**CITY OF PORTLAND, ME
BOCA 1999 Plan Review Record
One and Two Family Dwelling**

Valuation: \$ 79,000.00 Plan Review # 08

Building Location: 181 Murray St. CBL: 161-B-009

Building Description: Single Family dwelling

FOUNDATION PLAN

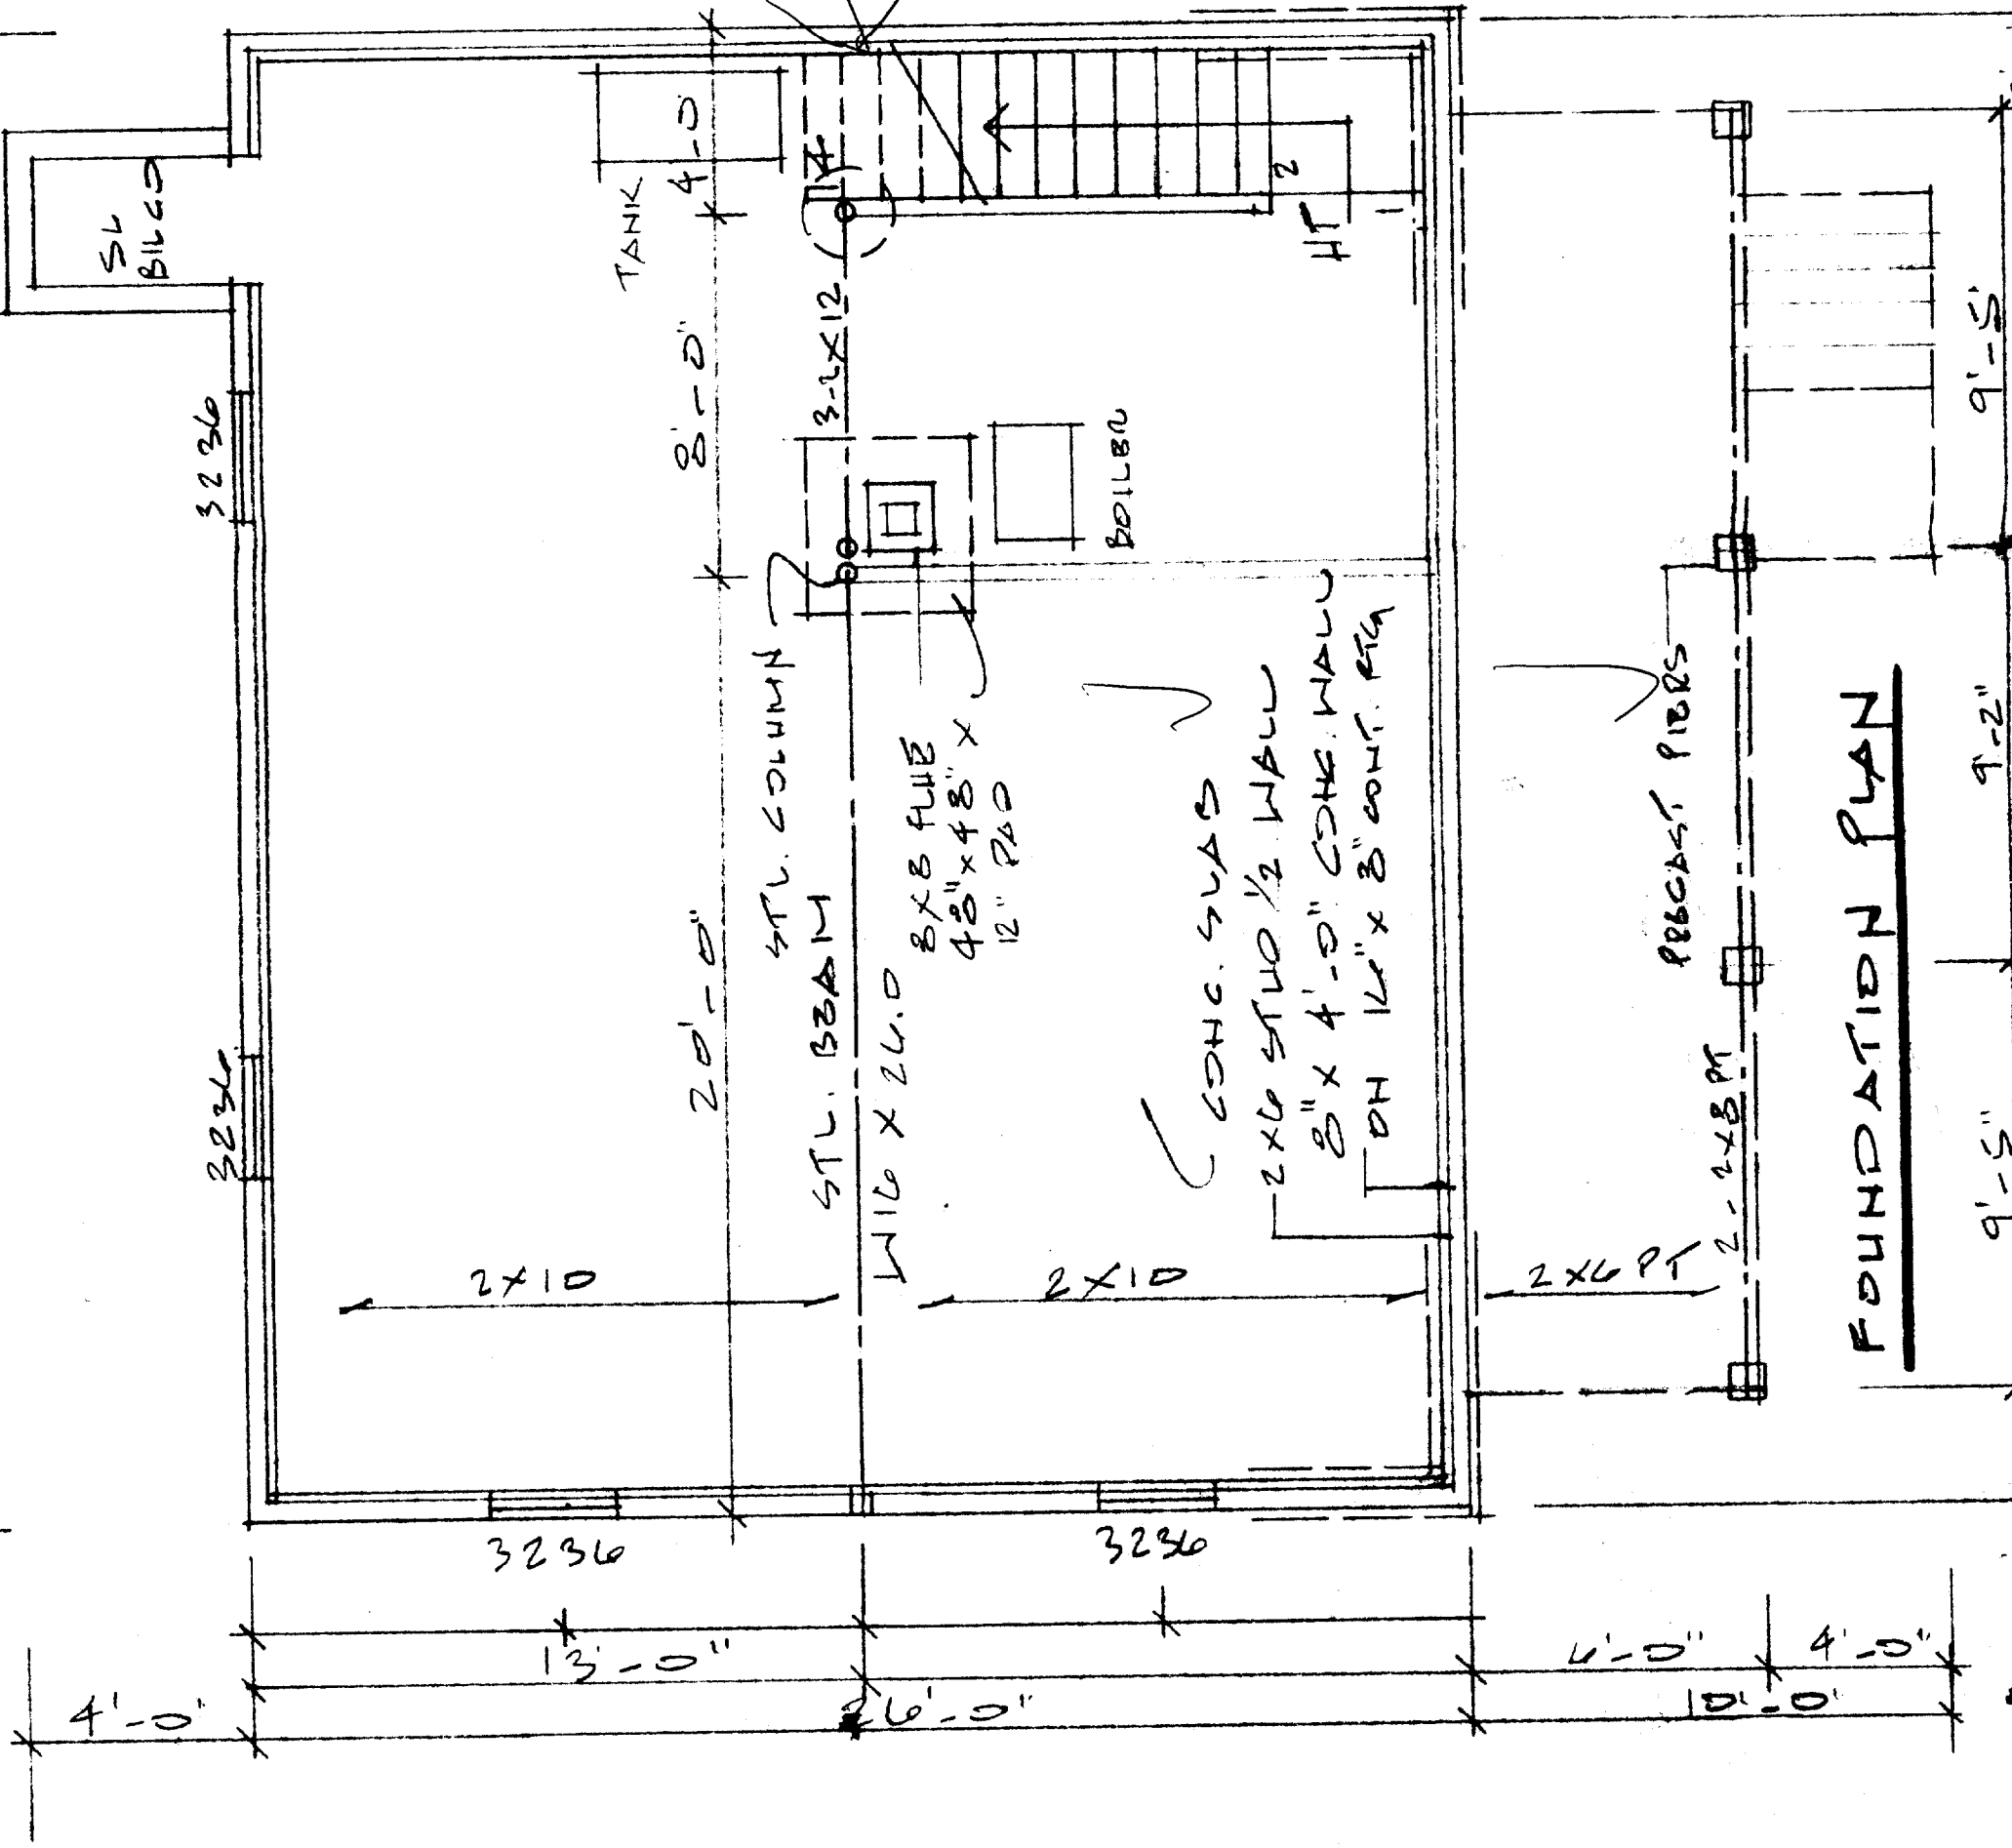
2.	Foundation drainage shall comply with section 1813.5.2.	1813.5.2
3.	Foundation anchors shall comply with section 2305.17	2305.17
4.	Water proofing and damp proofing shall comply with section 1813.0	1813.0
